A1 in Northumberland: Morpeth to Ellingham

Scheme Number: TR010059

7.6A Statement of Common Ground with Northumberland County Council

**Statement of Common Ground with
Northumberland County Council**

| Sustainability                                                                    |  | Status                                       |            | Project Title                          |            |

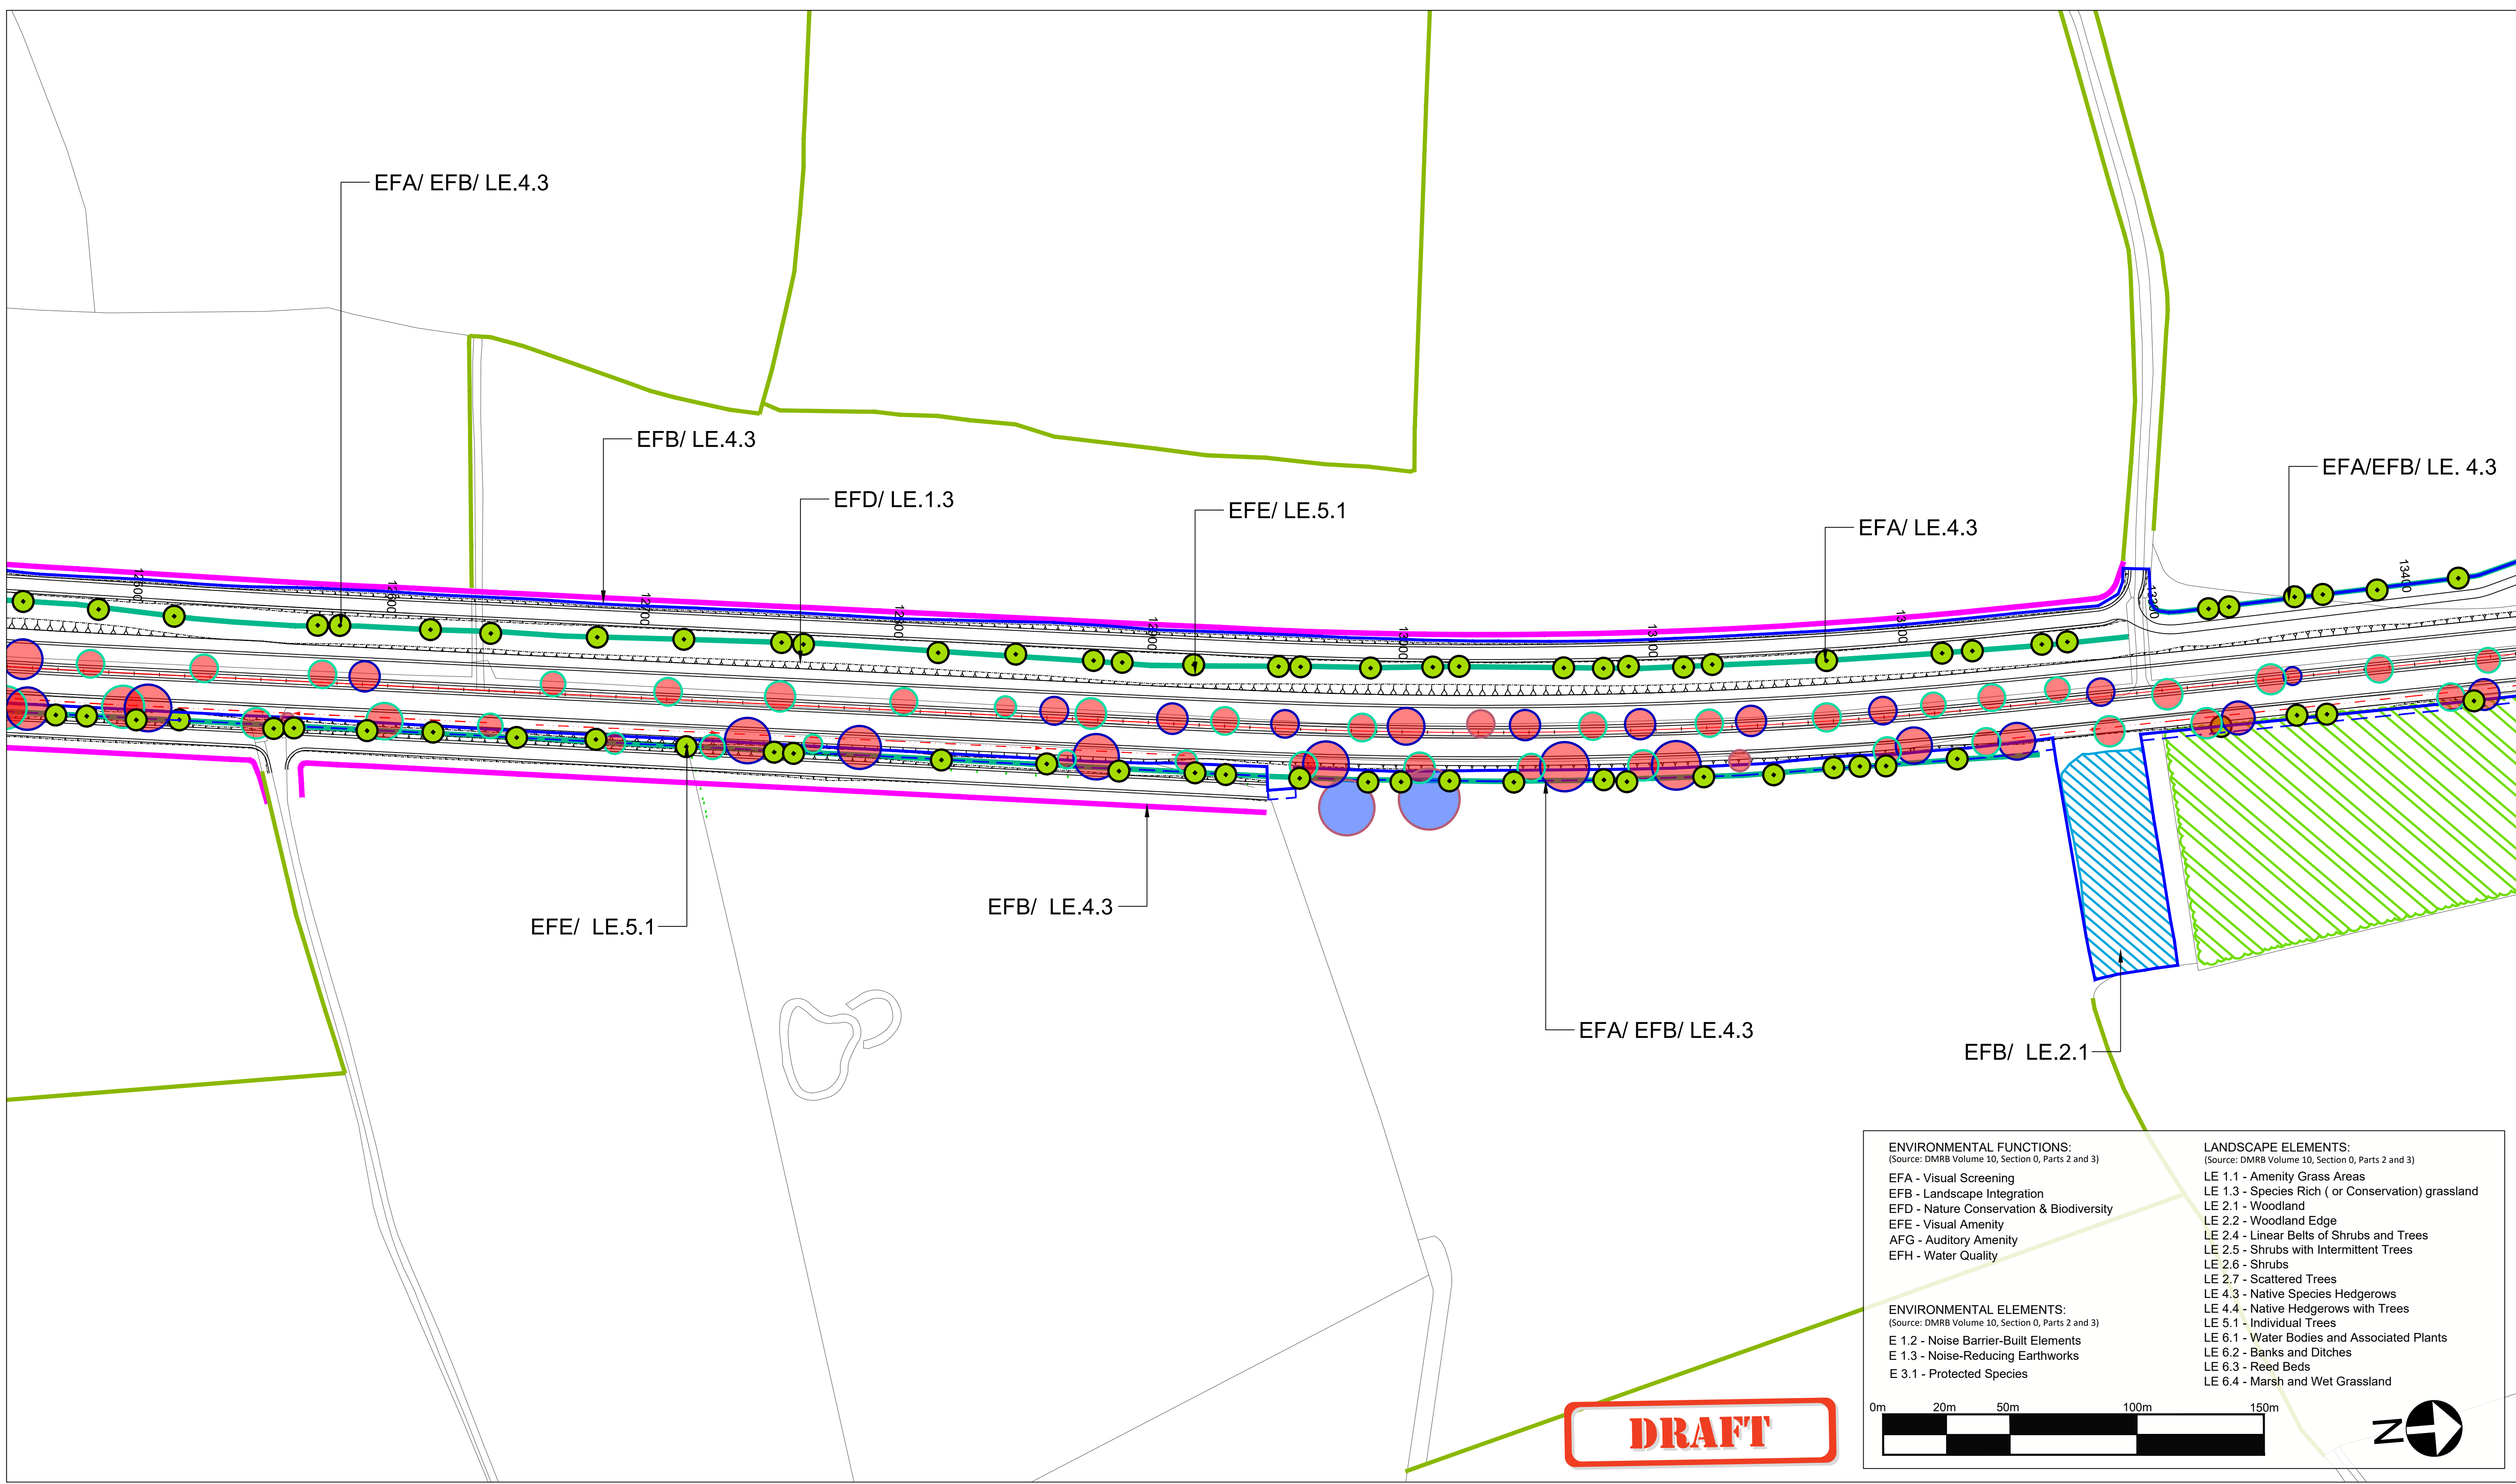
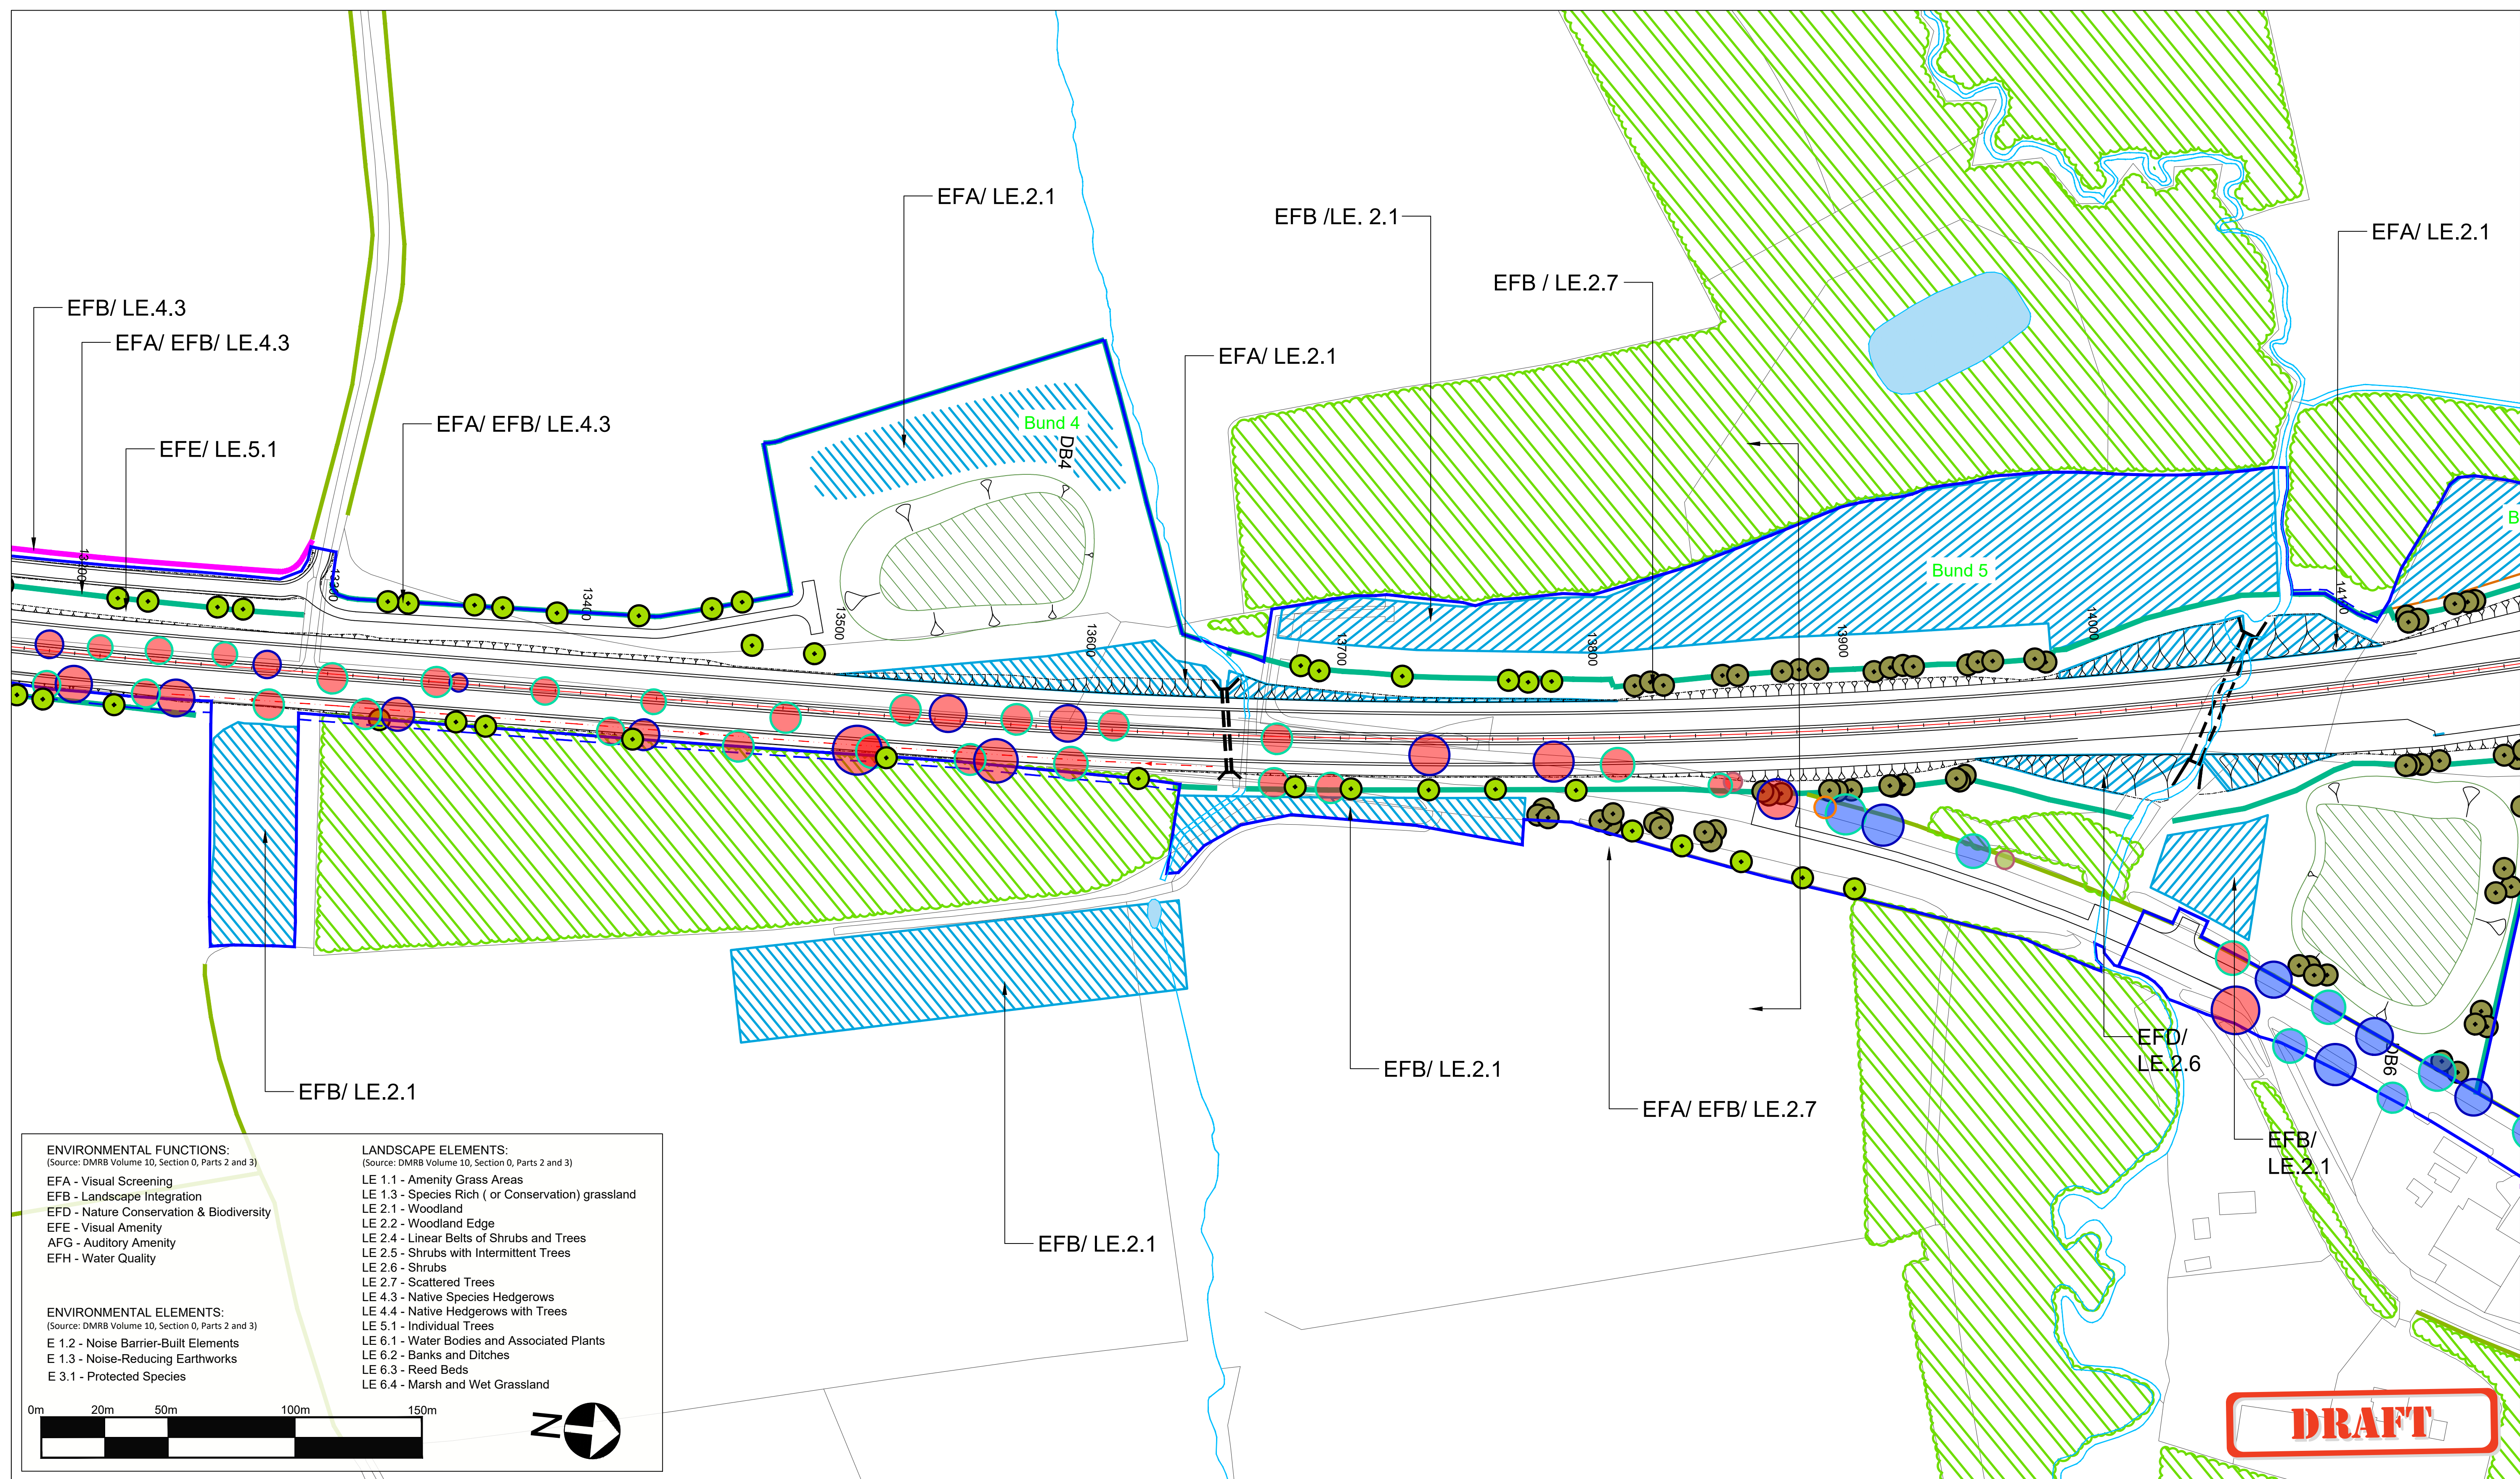
Date	Form of Correspondence	Key Topics Discussed and Key Outcomes
6/1/21	Email exchange with Mary Fisher, and Andy Williams (on behalf of the Applicant)	Key Topic Email exchange regarding the design of the Coronation Avenue (number, spacings and frequency). Reference to further discussion with NCC tree officer to also get feedback. Key Outcome Email received from NCC confirming that they are in agreement with the proposed replacement strategy for the Coronation Avenue, as per Appendix LV.2 to Written Question LV.1.8 at Deadline 1 [REP1-032].
07/01/21	Call between NCC and drainage specialist.	Key Topic and Outcome Follow up call to discuss surface water drainage strategy for the Scheme.
14/01/21	Meeting with NCC and the Applicant	Detailed discussion around issues identified with the Rights of Way and Access Plans and DCO Schedules. Key Topic NCC stated that it was unclear from the DCO plans which roads are to be adopted and which are not. NCC also requested clarification as to the extents of stopping up of the existing A1 at the southern end of the detrunking section, at Priest's Bridge. NCC believe stopping up of highway should continue further south than is shown on the Rights of Way and Access Plans. NCC stated that the extent of soft estate to be adopted is unclear, with respect to earthworks, verge, landscaping and detention basins. Key Outcome A scheme overview plan showing the extent of roads to be adopted was produced and issued to NCC on 08/02/21. Extents of stopping up of the existing A1 at the southern end of the detrunking section, at Priest's Bridge, amended as per NCC's suggestion. Updated Rights of Way and Access Plans issued at Deadline 02. [REP2-003]. The Applicant is unable to confirm exact limits of soft estate to be adopted at present. Such details are subject to detailed design, with the exception of the detention basins for adoption which can and will be confirmed.
